Statement of Response to ABP's Opinion

**Proposed Residential Development,
Ballymany,
Newbridge,
Co. Kildare**

Briargate Developments Newbridge Limited

February 2022

JOB	STRATEGIC HOUSING DEVELOPMENT Ballymany, Newbridge
CLIENT	Briargate Developments Newbridge Ltd
TITLE	Proposed Masterplan
DATE	21.04.21
DRN	MK
SCALE	1-1000 @ A1
CHECKED	MK
DRWG NUMBER	P20-071K-RAU-XX-XX-DR-A-31001
REVISION	P03.02

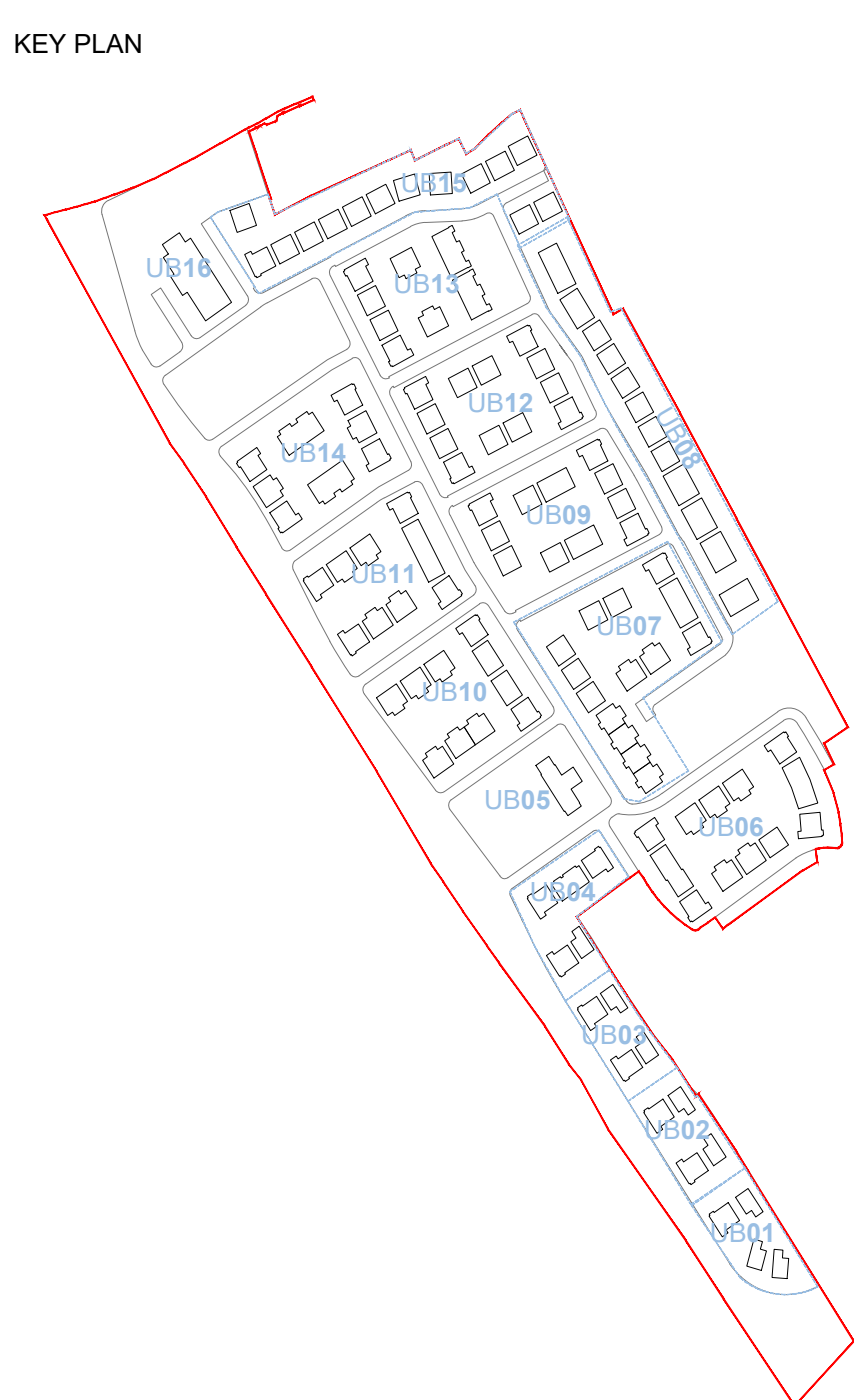
- 1. Further consideration / amendment of the layout of the scheme along the southern portion of the site, along the distributor road and adjoining Phase 1, to ensure the proposed development protects the residential amenities of houses approved under Phase 1.**

- 2. Further consideration/amendment of the layout of the public open space, and surface car park at the northern boundary with Standhouse Lane (Road) to improve the relationship with Standhouse Road and the public realm. The layout should ensure adequate permeability through the site.**

The masterplan layout has developed to provide enhanced connectivity to the link road (referred to as distributor road above) with additional open space provided towards Ballymany Road. This has been achieved by relocating the approved creche facility into the heart of the scheme; the facility itself has been enlarged to provide a central community facility to serve the full development of the site, including Phase 1 proposals.

The number of units proposed along the southern section of the Link Road has been reduced since the Tripartite meeting to better reflect the density of the Phase 1 lands. With the reduction in the number of units along this section of the Link Road, greater setbacks between the units under construction in Phase 1 and the

subject application have been achieved resulting in the proposed dwellings being located and designed to protect the amenity of the current Phase 1 scheme while complimentary materiality has been selected to ensure a cohesive scheme is created.

The design has been revised to provide a set-back landmark building within a soft landscaped setting alongside the proposed junction, while parking has been integrated with the streetscape. The reduced car parking area allows a more significant open space presentation. Footpath links towards the Newbridge Railway Station are provided along this frontage, to link seamlessly with existing footpaths to the east along Standhouse Road.

Overall Site Layout Plan
PHASING PLAN AND CHARACTER AREAS PLAN

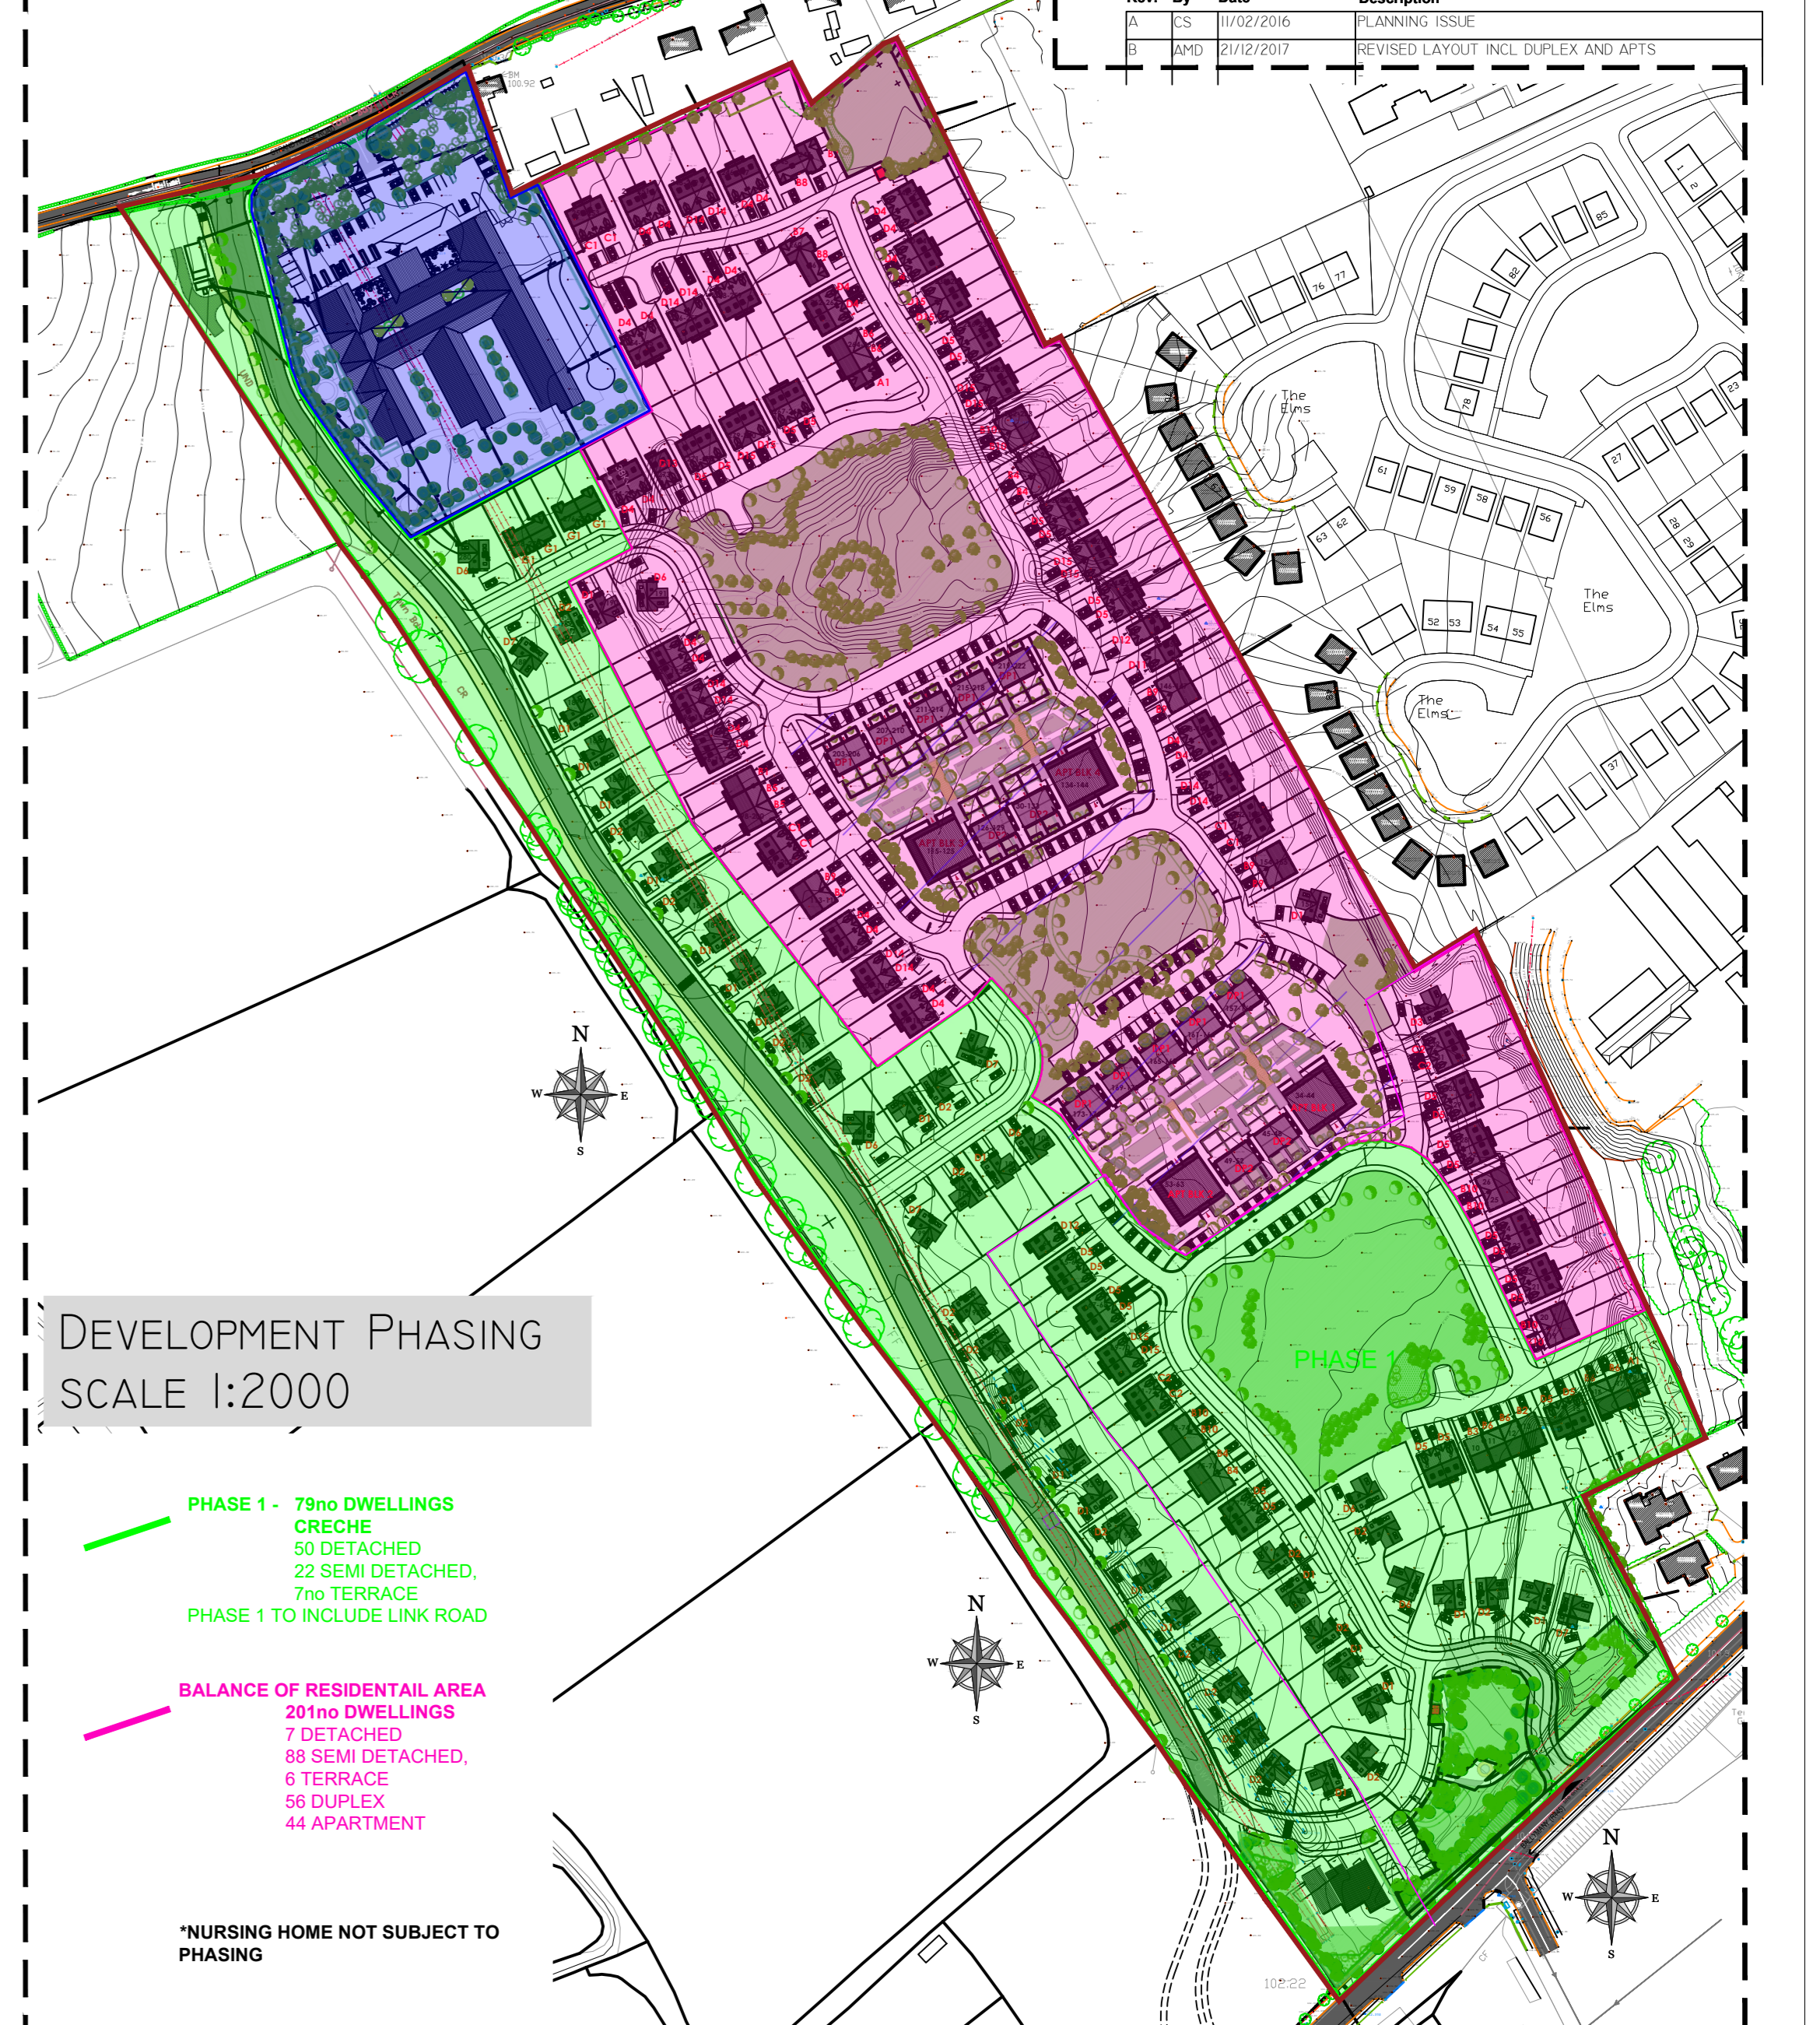
3. A report providing a clear rationale and/or justification for the extent, location and visual dominance of proposed car parking.

The internal layout and parking provision structure has been changed and parking reduced in response to the ABP Opinion, to the extent that there is no visual dominance of car parking. Car parking is provided to the front of residential units, with most housing units having 2 no. car parking spaces within their curtilage. Car parking for duplex units is provided in a similar manner, to the front of the dwellings and car parking for the apartment building is located to the east and west of the building.

The pattern of car parking provided is similar to the pattern permitted on the lands under Ref. 16/658 (ABP-249038) as shown in the original Van Dijk Architects Site Layout Plan enclosed.

TYPICAL CROSS SECTION - LINK ROAD
SCALE: 1:100

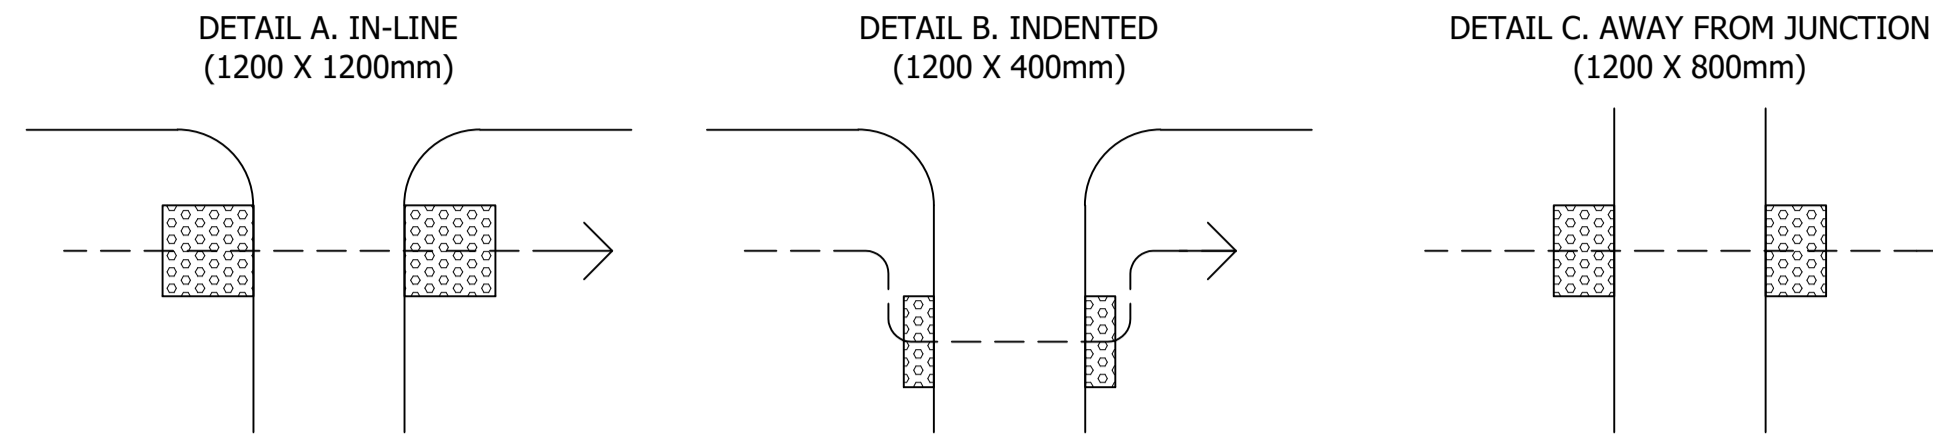
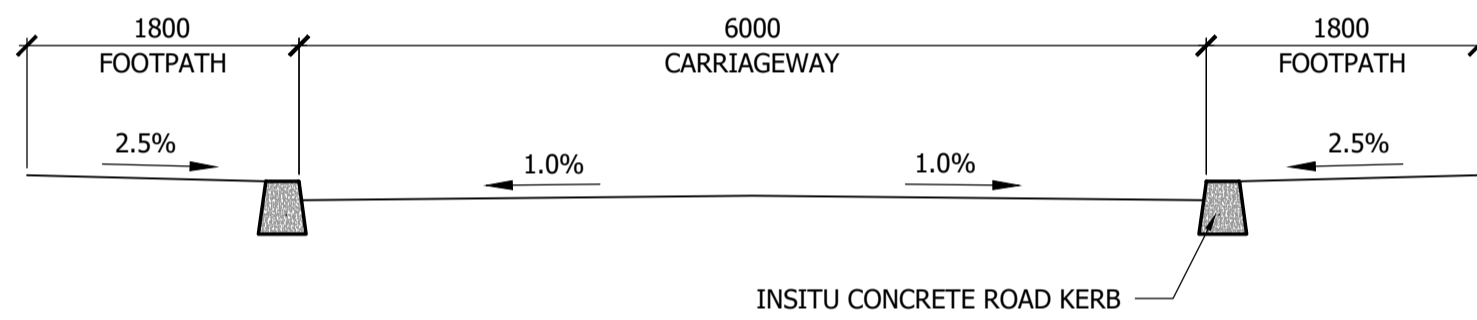
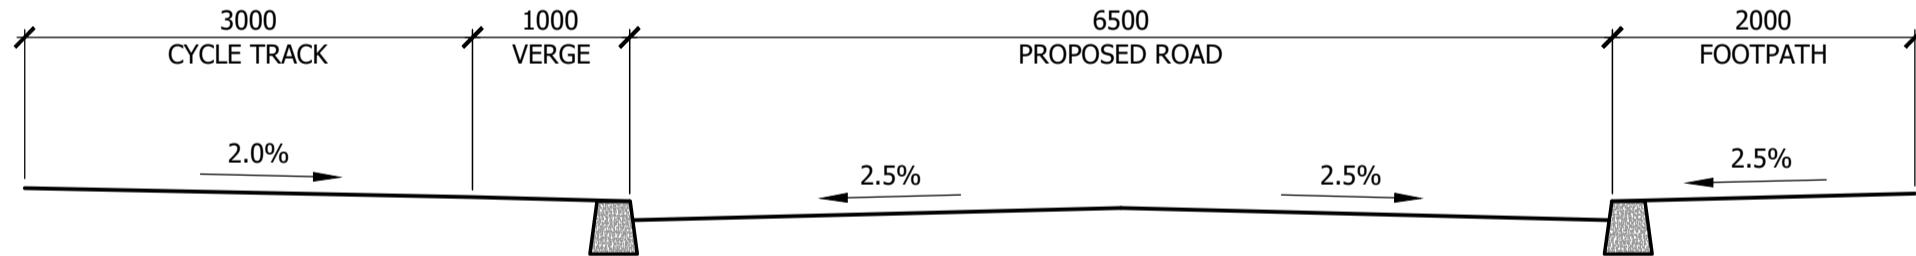
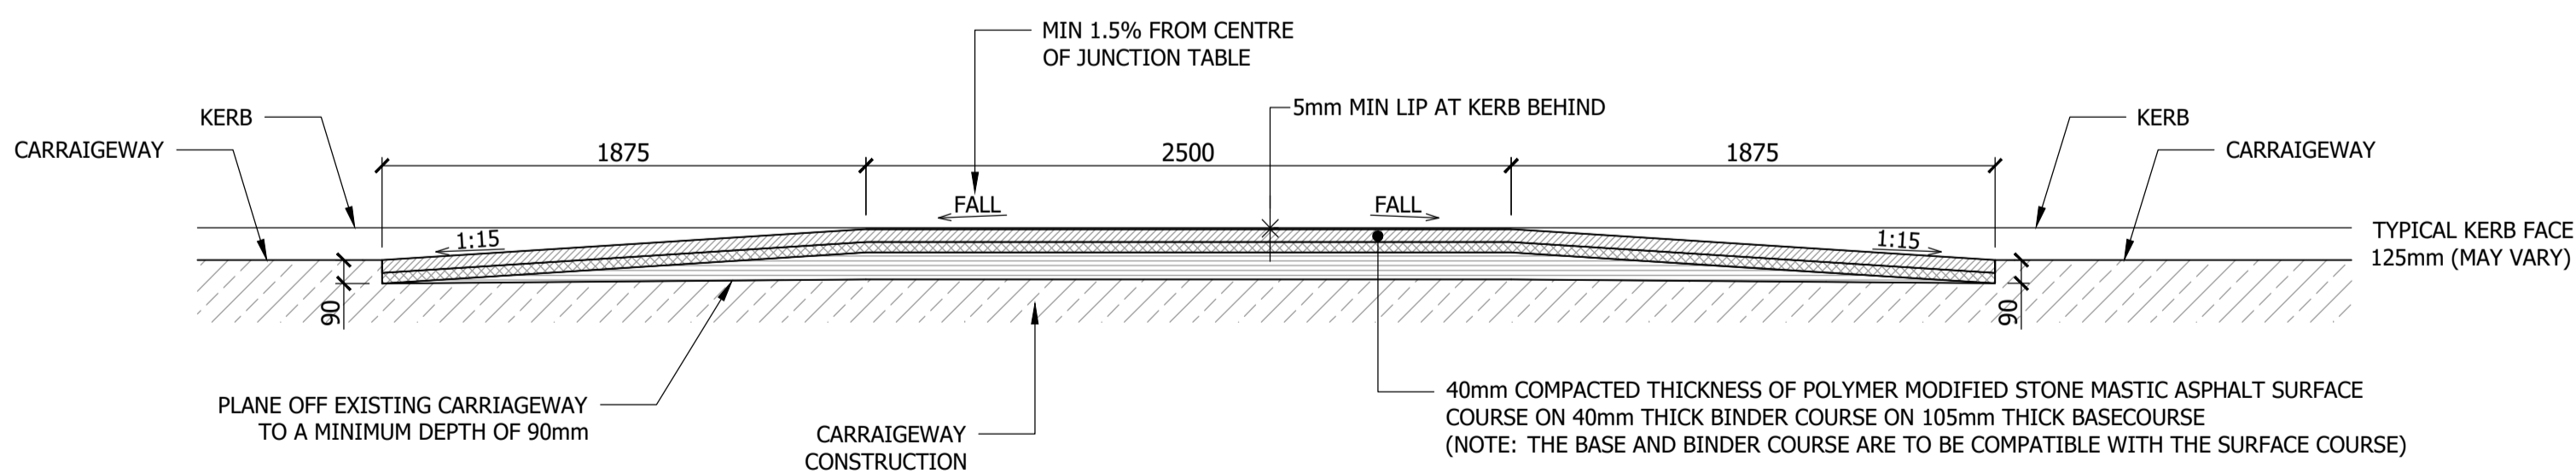
- 5. Further consideration / amendment of the proposed hierarchy of streets within the scheme, including the provision of homezones to ensure that through traffic is directed towards the distributor road and not through the scheme.**

The MAL drawing below shows a clear strategy for a roads and streets hierarchy (Dwg Ref. D1920-MAL-00-XX-C-033). The main link road runs externally along the western edge and discourages through-traffic. A central 6m carriageway spine route facilitates internal car traffic and feeds out to the link road. The homezone network is traffic calmed with reduced speed limit to create safe neighbourhoods

of distinct character with pedestrian and residents safety at the forefront, while the materiality of these streets allow for wayfinding and definition.

Section Detail A
Open Space Natural Play
Scale 1 : 150 @ A1

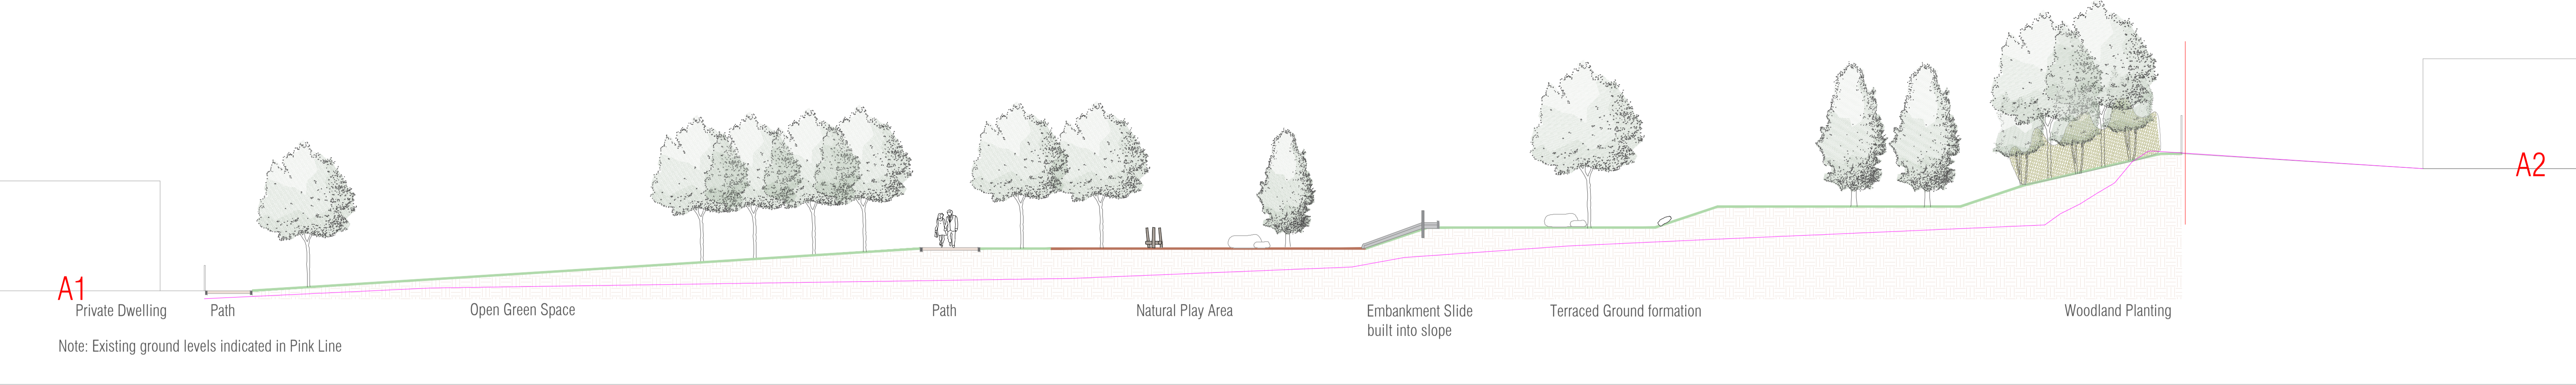
- 3. Further consideration / amendment of the layout to ensure adequate provision of safe active and passive public open spaces. A landscaping and design plan with associated drawings and documentation should be submitted with any application clearly indicating how the areas of public open space integrate with and enhance the development.**

The landscape design team has worked with the design architects and has met and consulted with the Parks Department in Kildare County Council to provide a comprehensive and integrated open space design, which works with the proposed built fabric and circulation through the scheme. Homezones have been introduced to provide a safe movement environment with an animated streetscape, dedicated play areas and larger open spaces. The existing topography of the site has been considered to ensure integration of useable open spaces within the site boundaries and integrating with the Phase 1 open space and movement proposals. Please refer to the Landscape Drawings and Report prepared by Jane McCorkell Landscape Architect for further details. The Open Space Plan Dwg Ref. PP255-03-03 prepared by Jane McCorkell illustrates the connectivity between all areas of public open space.
